From: Grant Logan <grantlogan@bigpond.com>
To: Michael Buckley <michael.buckley@planning.nsw.gov.au>
CC: <assessments@planning.nsw.gov.au>
Date: 1/12/2010 11:00 am
Subject: Online Submission from Grant Logan (support)

Submission for Job: #3920 MP10_0048 - Headland Park and Northern Cove - Main Works
https://majorprojects.onhiive.com/index.pl?action=view_job&id=3920

Site: #188 Barangaroo (formerly East Darling Harbour)
https://majorprojects.onhiive.com/index.pl?action=view_site&id=188

**MAIN WORKS APPLICATION
CARPARK & FUTURE CULTURAL FACILITY
PLAN RL 25.0**

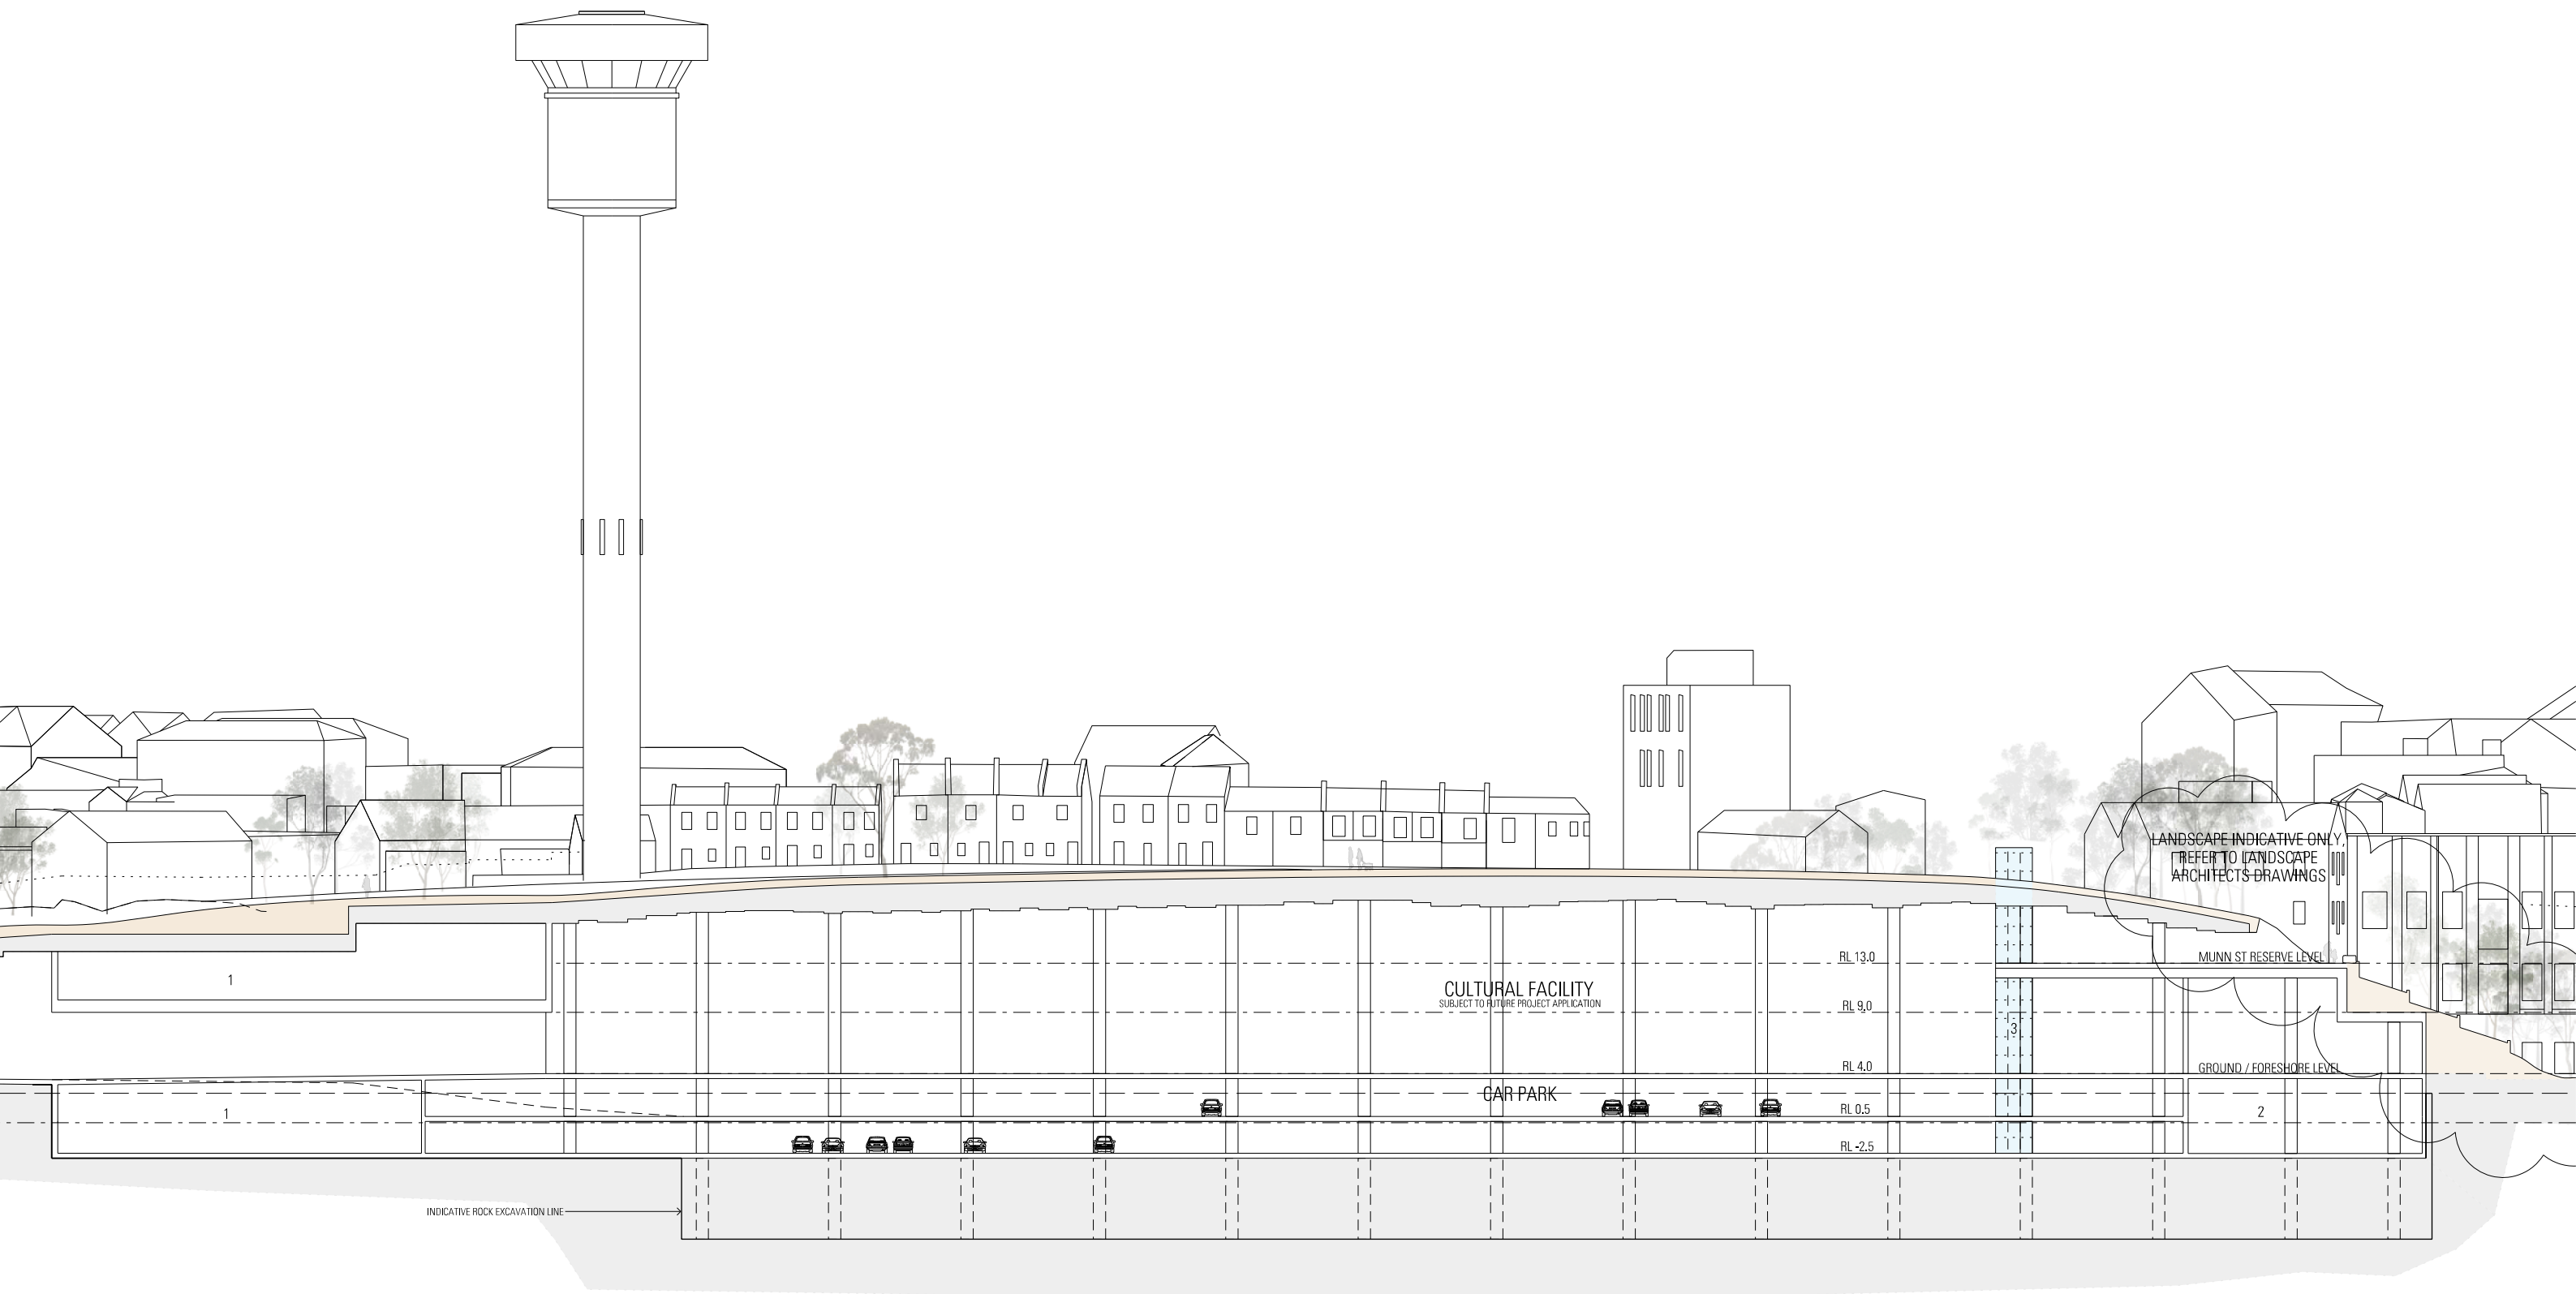
I am most concerned that the car park entrance has been (as I understand it) modified so that the only entry/exit is off Dalgety Road/Towns Place. I would have thought, from a traffic flow perspective, this would be better located directly off Hickson Rd. Obviously living in Dalgety Rd we would be impacted by the increased traffic. However, it will also be detrimental to traffic flow in the surrounding streets - particularly Argyle and Kent Streets.
